MOLLETT'S FARM

Written Representation for Deadline 5 from Mollett's Partnership (trading as Mollett's Farm)

This document contains our Deadline 5 submission to the Examining Authority, relating to the Sizewell C development application.

DRAWING TITLE:
 CONSTRUCTION PHASE

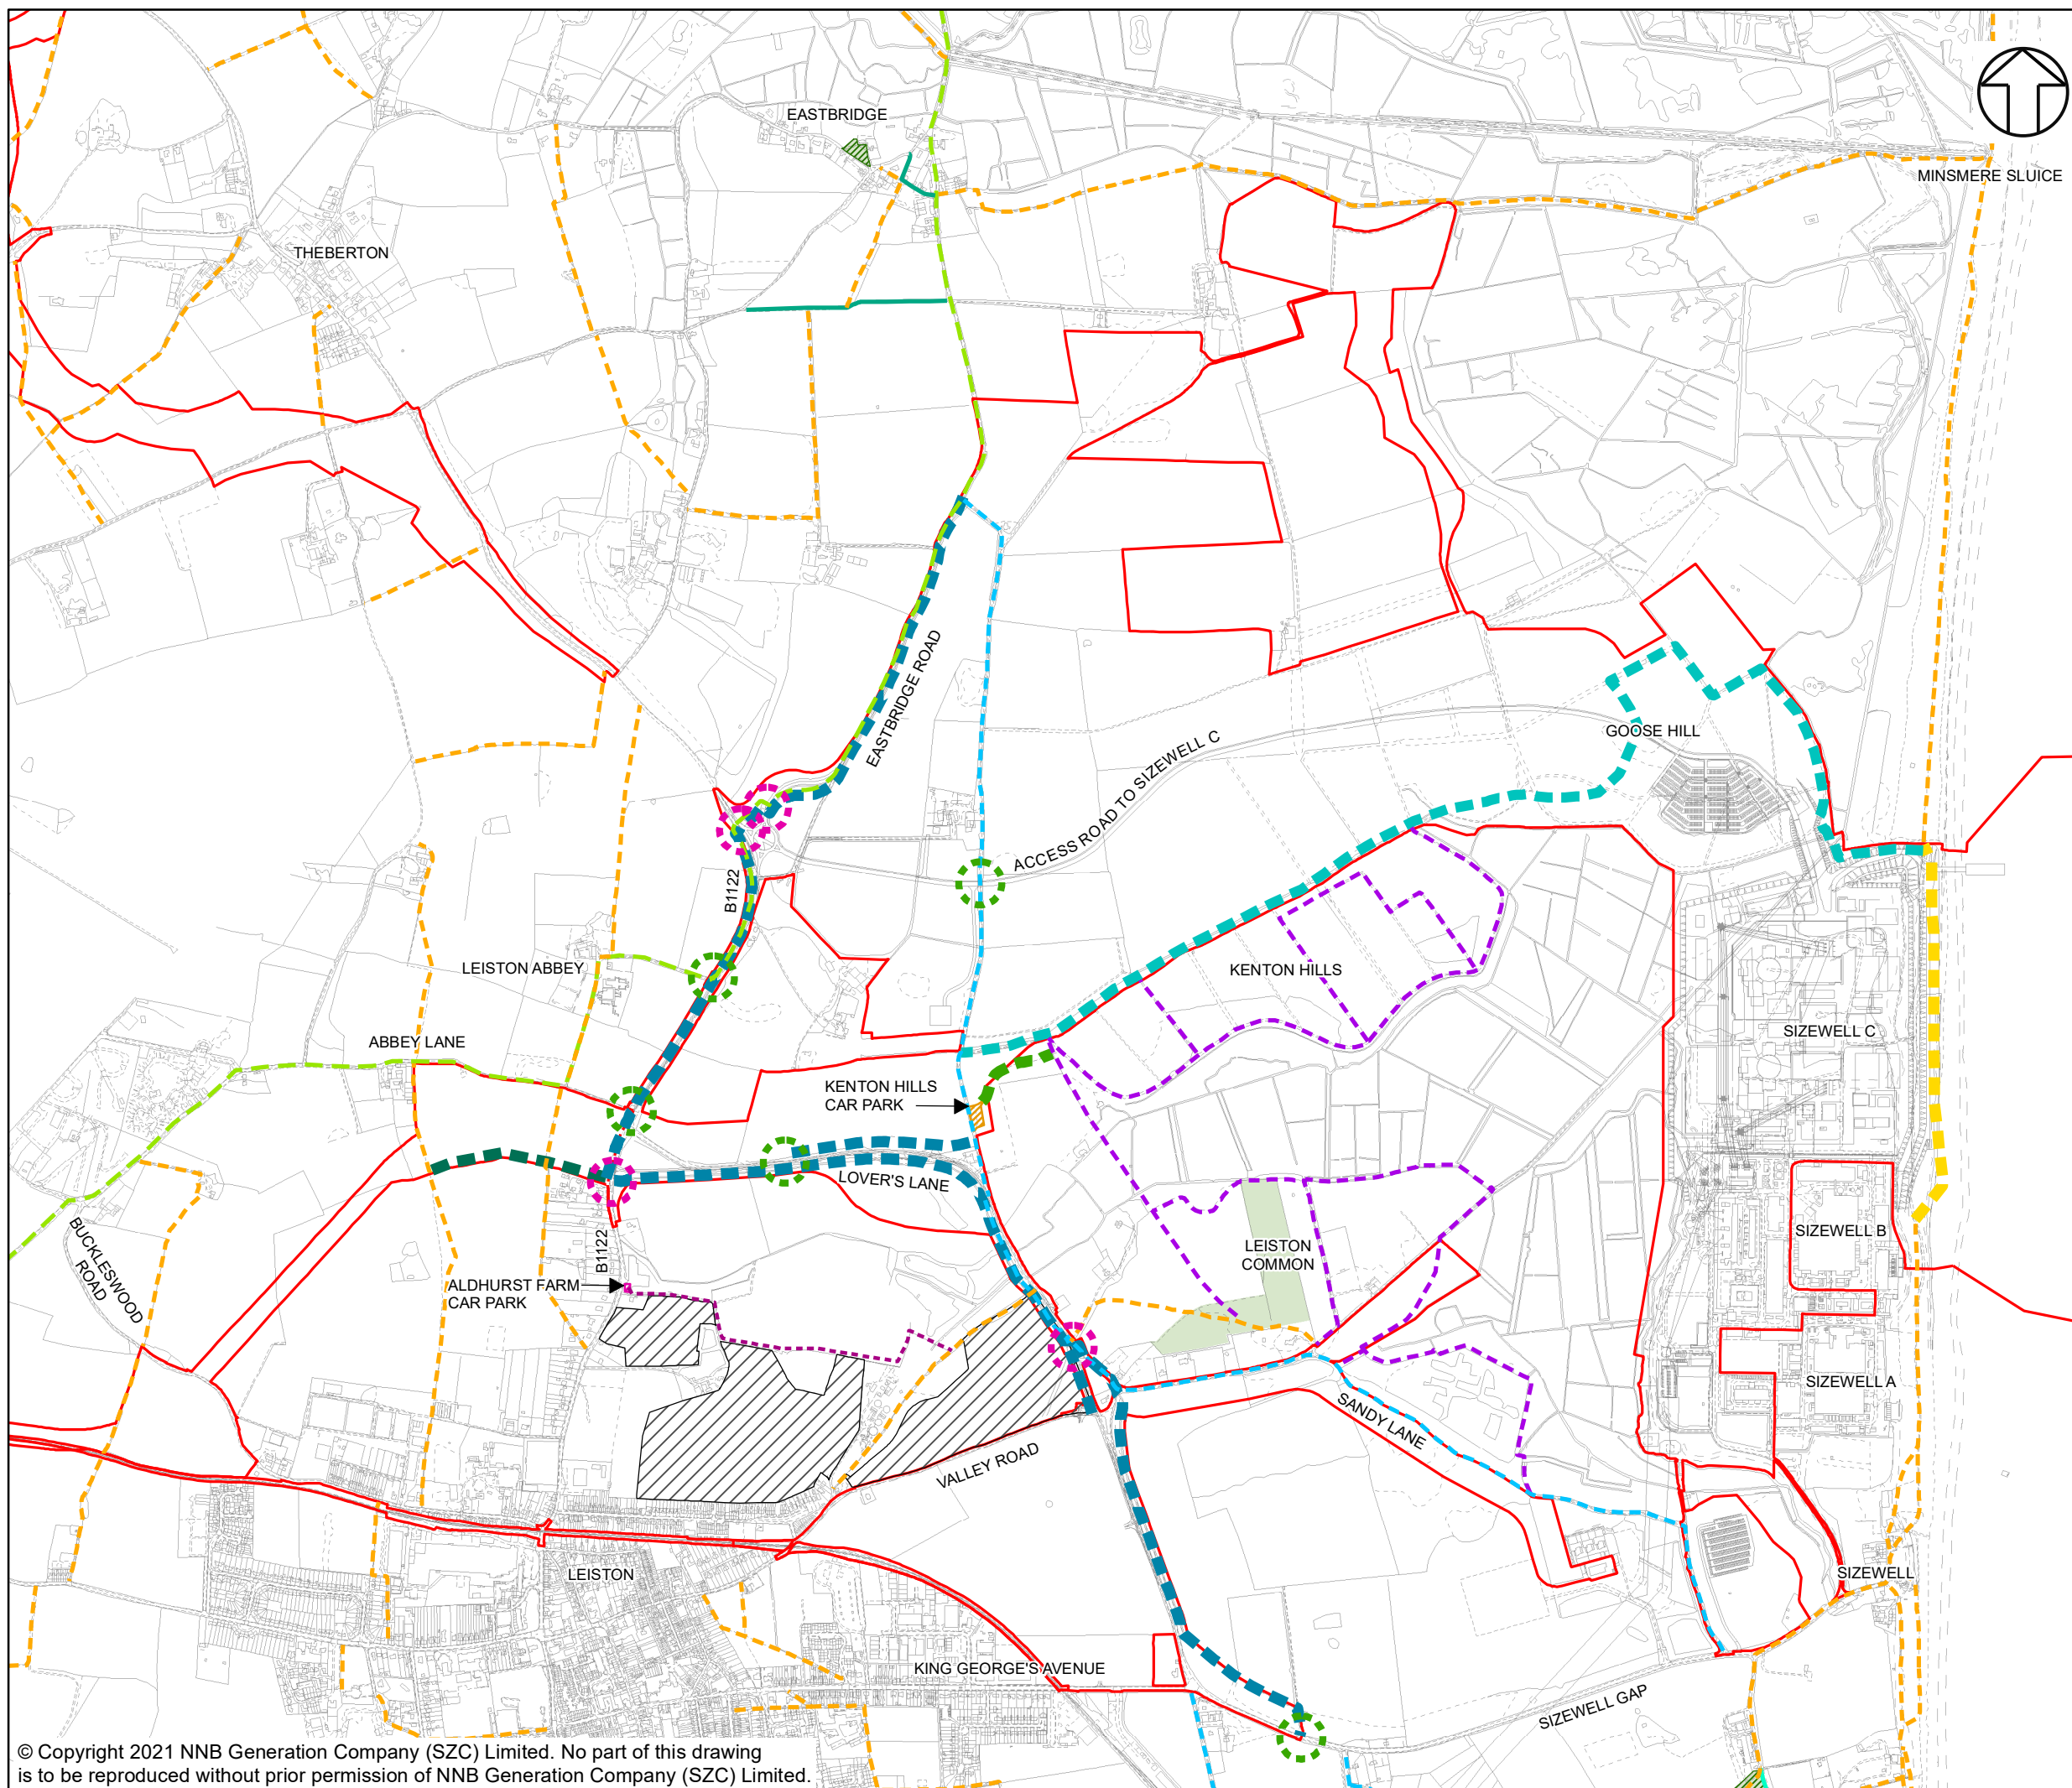
- Suitable visual screening and noise attenuation fencing needs to be incorporated around the eastern TVB contractors' compound during construction and use.

- Revisions to the Public Rights of Way (PRoW) proposals to provide a linear footpath between the walled garden in the Farnham Hall area and the new roundabout at Friday Street.

- Access arrangements are inadequate. Opportunities still exist to make their current footpath and private means of access proposals more acceptable, and specifically by a linear footpath to which we should have access.

DRAWING TITLE:
 OPERATIONAL PHASE

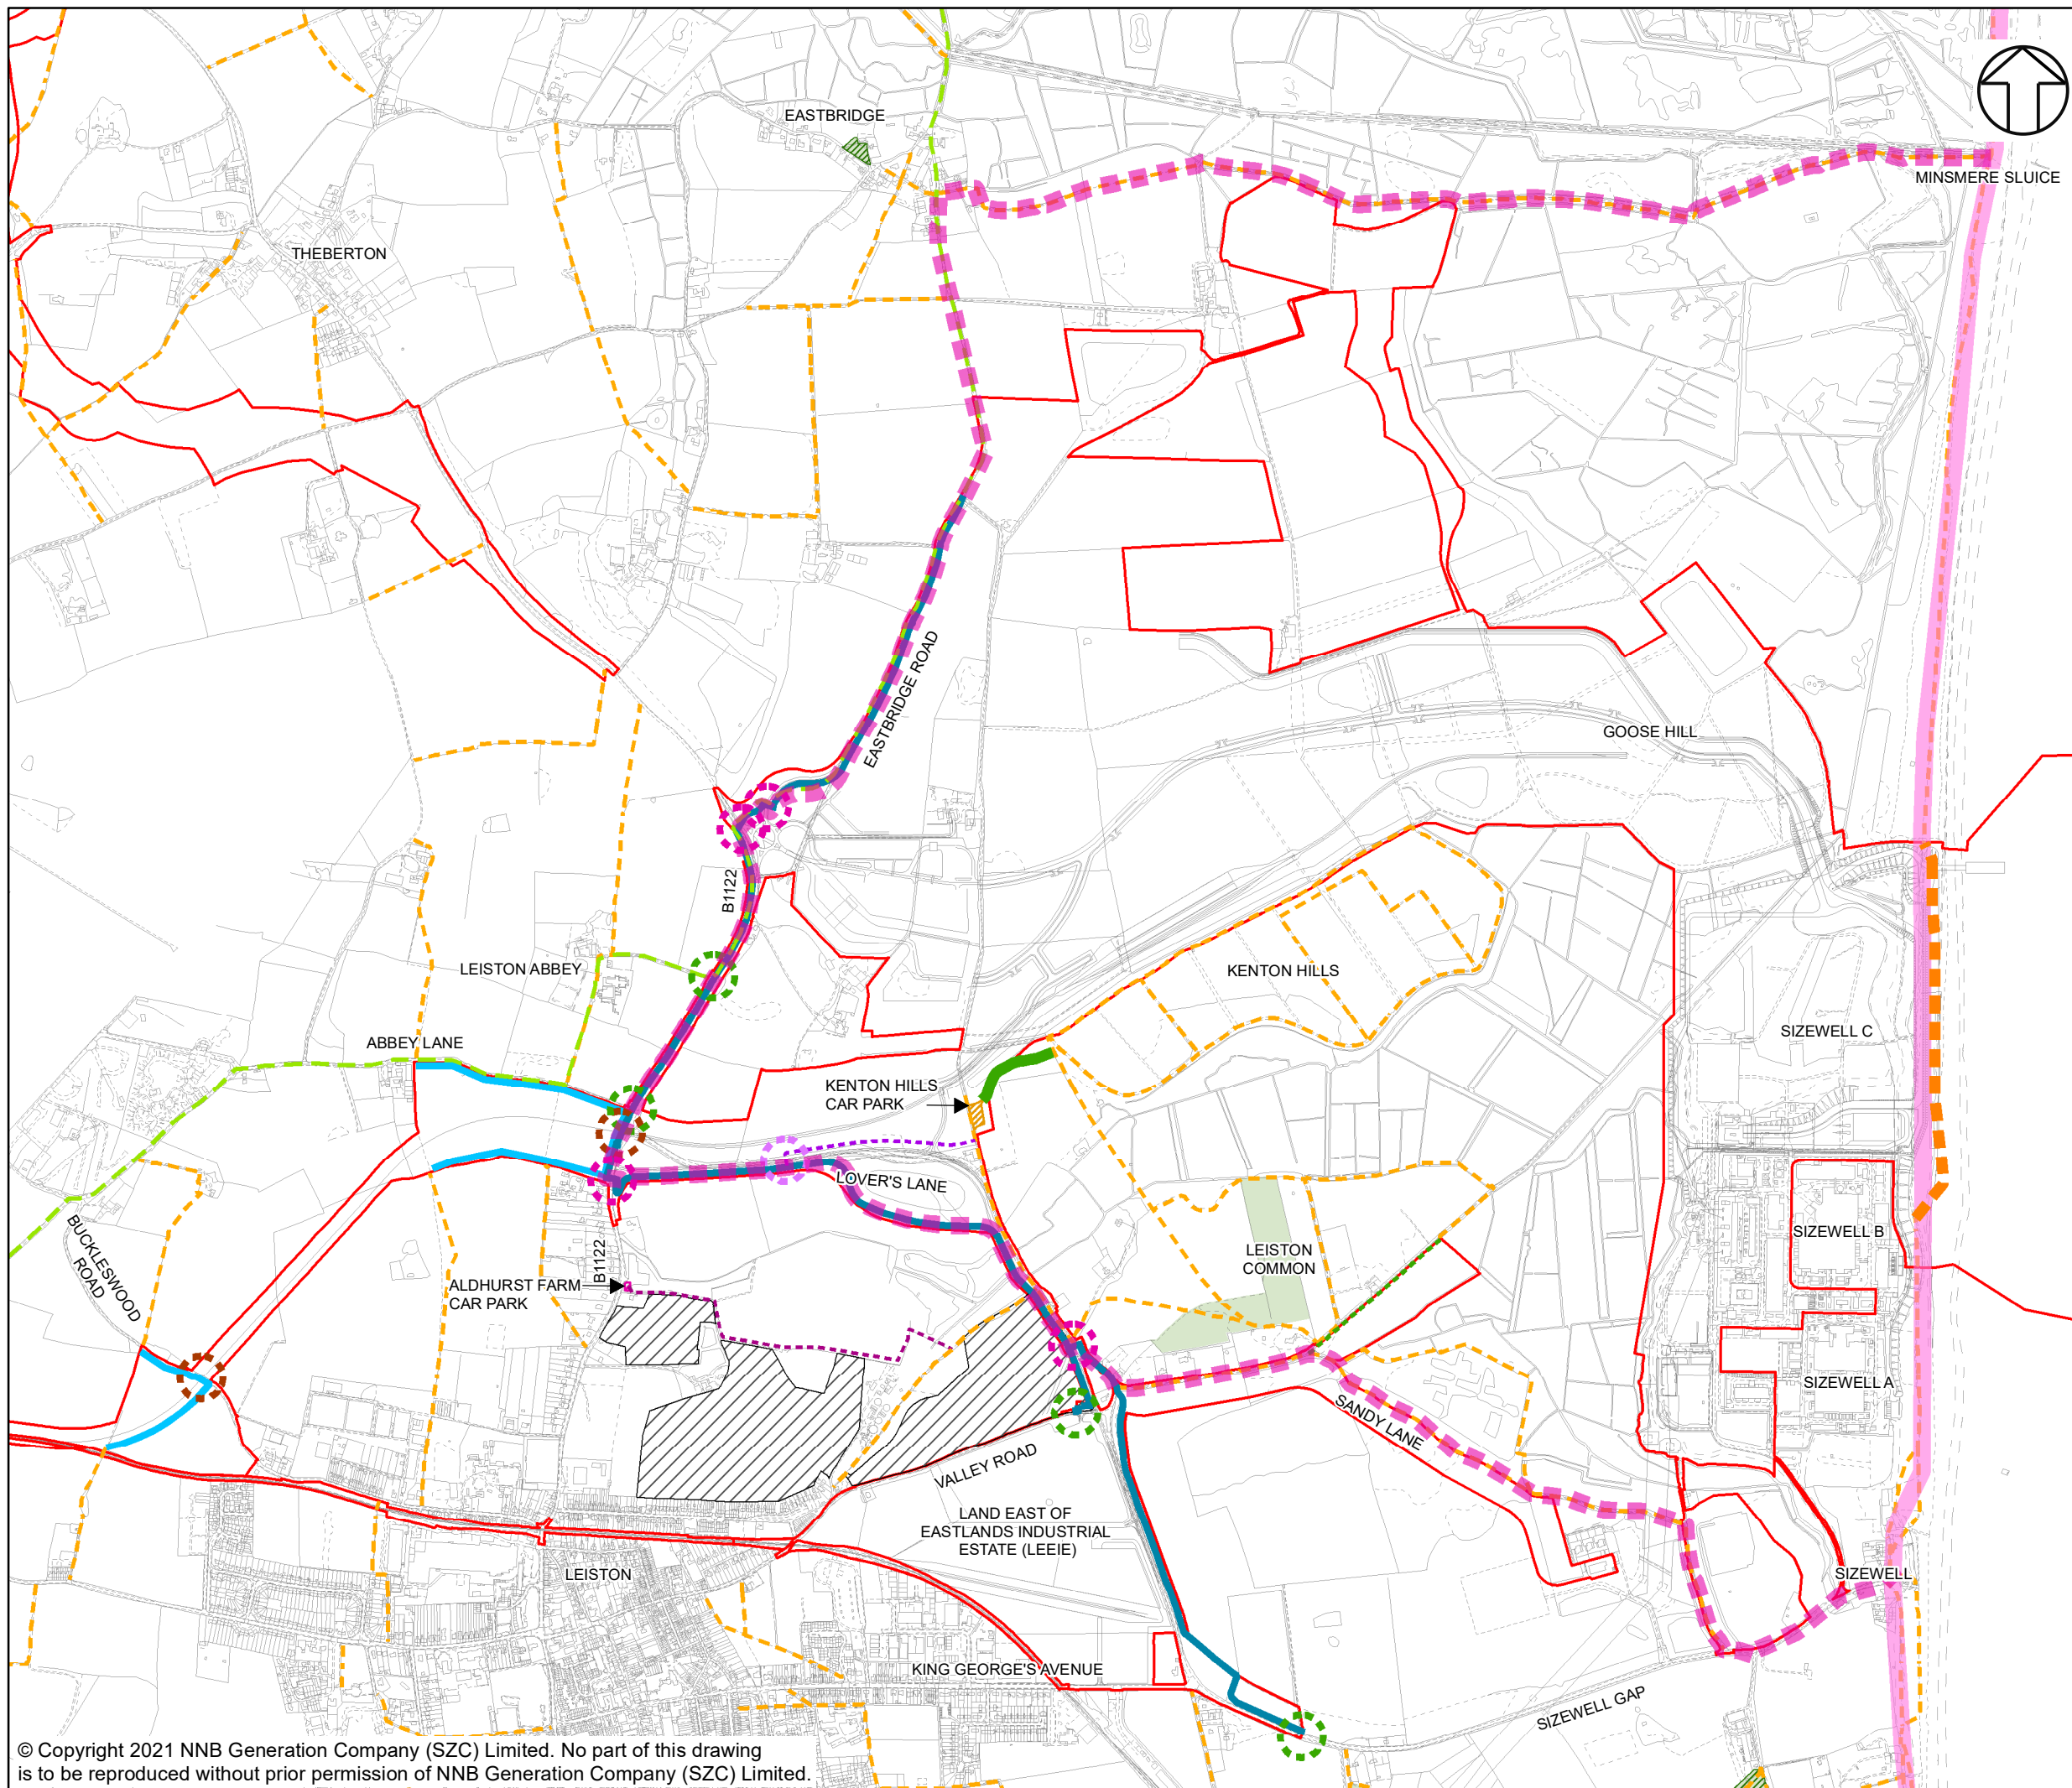
- We need a bund parallel to the route of the TVB that is long enough, high enough and wide enough to screen our business and the parts of our property enjoyed by guests and residents alike from road noise. This is currently absent in the applicant's proposals.

- Upon removal of the eastern TVB contractors' compound, the bunding and noise attenuation fencing needs to be extended up to the Friday Street roundabout and, as necessary, along the existing A12 to protect from traffic noise. This is to protect both us and neighbouring properties in the parish of Benhall (particularly the Old Police House and the two Stockhouse Cottages).

- Proper crossing points of the relevant arms of the Friday Street roundabout (with splitter islands) to enable safe crossing by pedestrians (considering that these may be going to or from relevant combinations of Saxmundham, Benhall Green, Benhall Low Street, Farnham, Stratford St. Andrew, Mollett's Farm, Farnham Hall, Foxburrow Wood, Greenwood Burial Ground and Friday Street).
